Application Ref: H08-0954-25

Proposal: **Proposed detached 4 bed dwelling**

Location: **Riseholme Farm, Gosberton Risegate, Spalding, PE11 4ET**

ADDITIONAL INFORMATION REQUIRED

SHEET
Proposed Block Plan

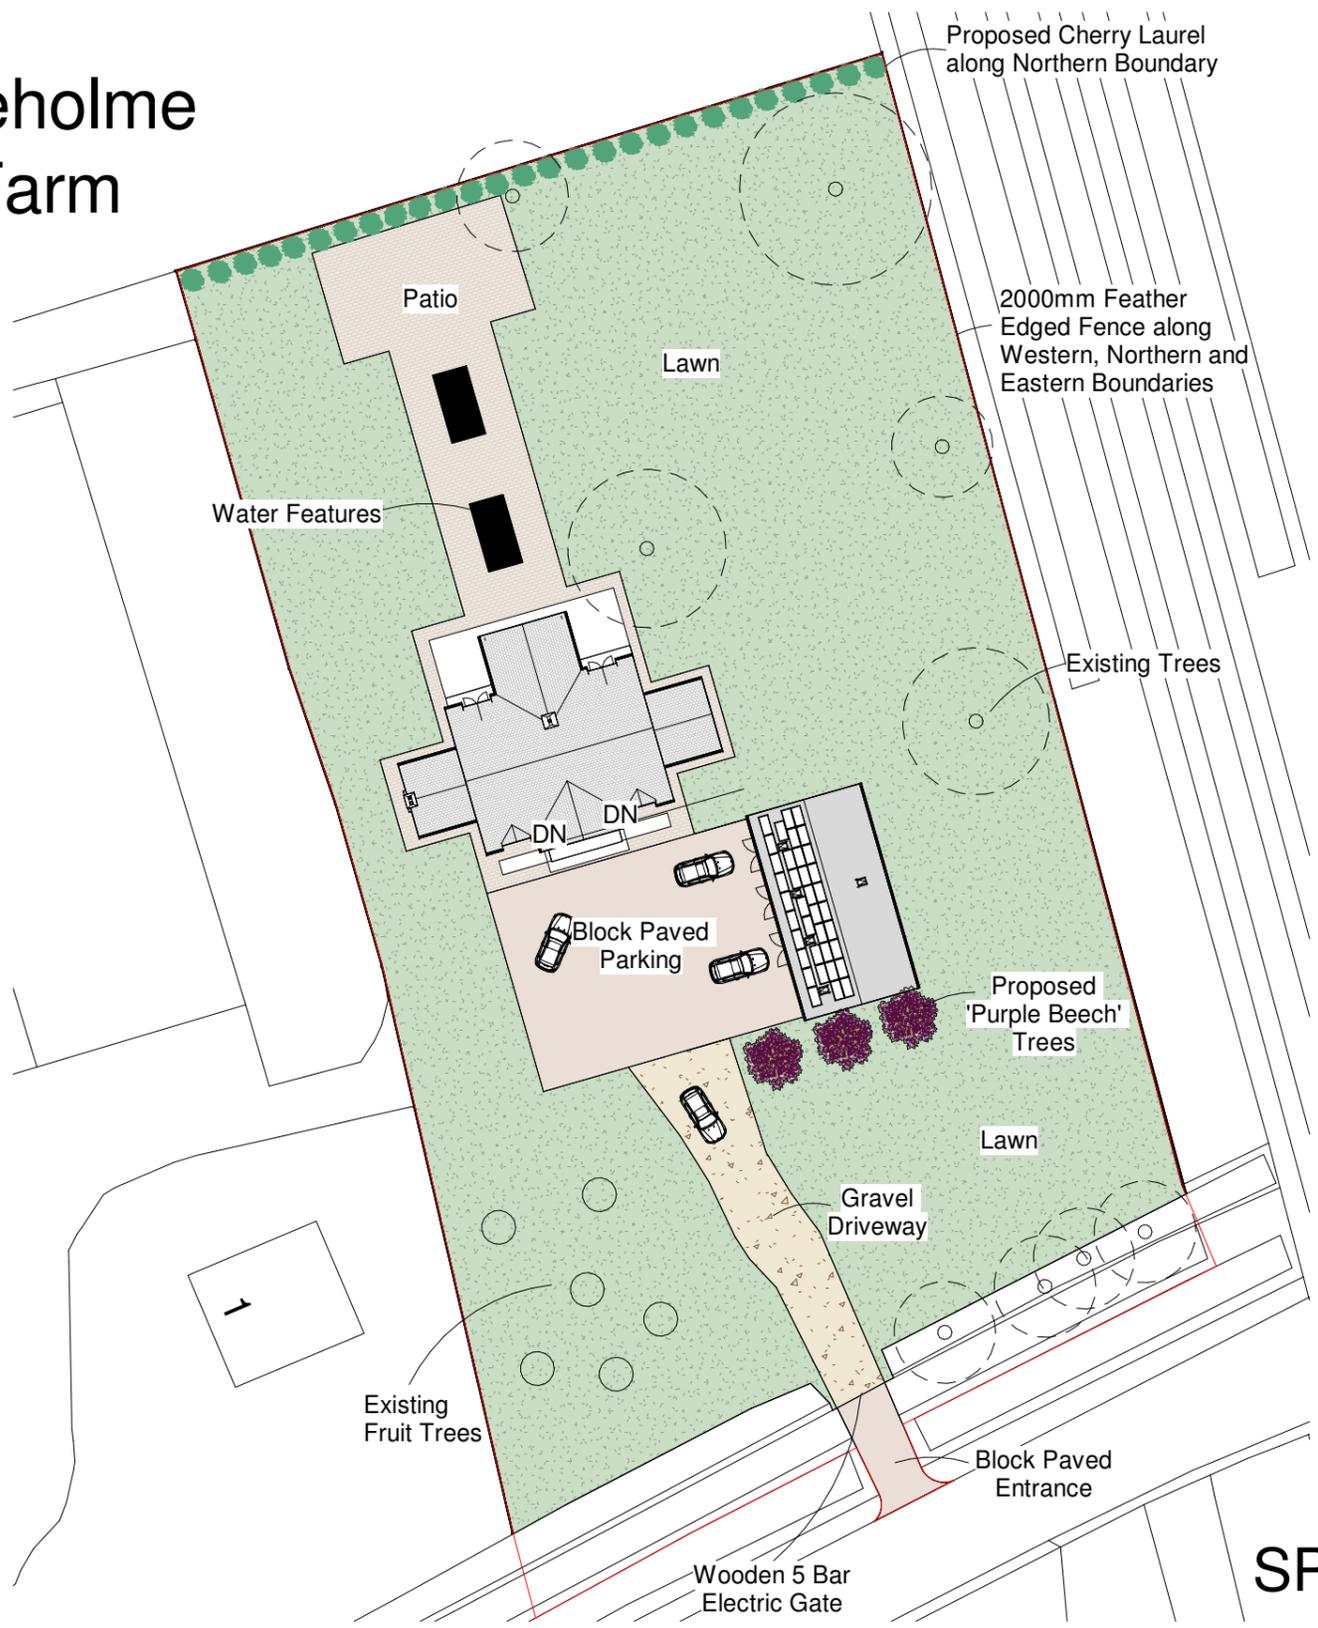
The existing access is to be utilised, the access construction cannot be block paved and should be to LCC Spec. A note should be added to the proposed block plan.
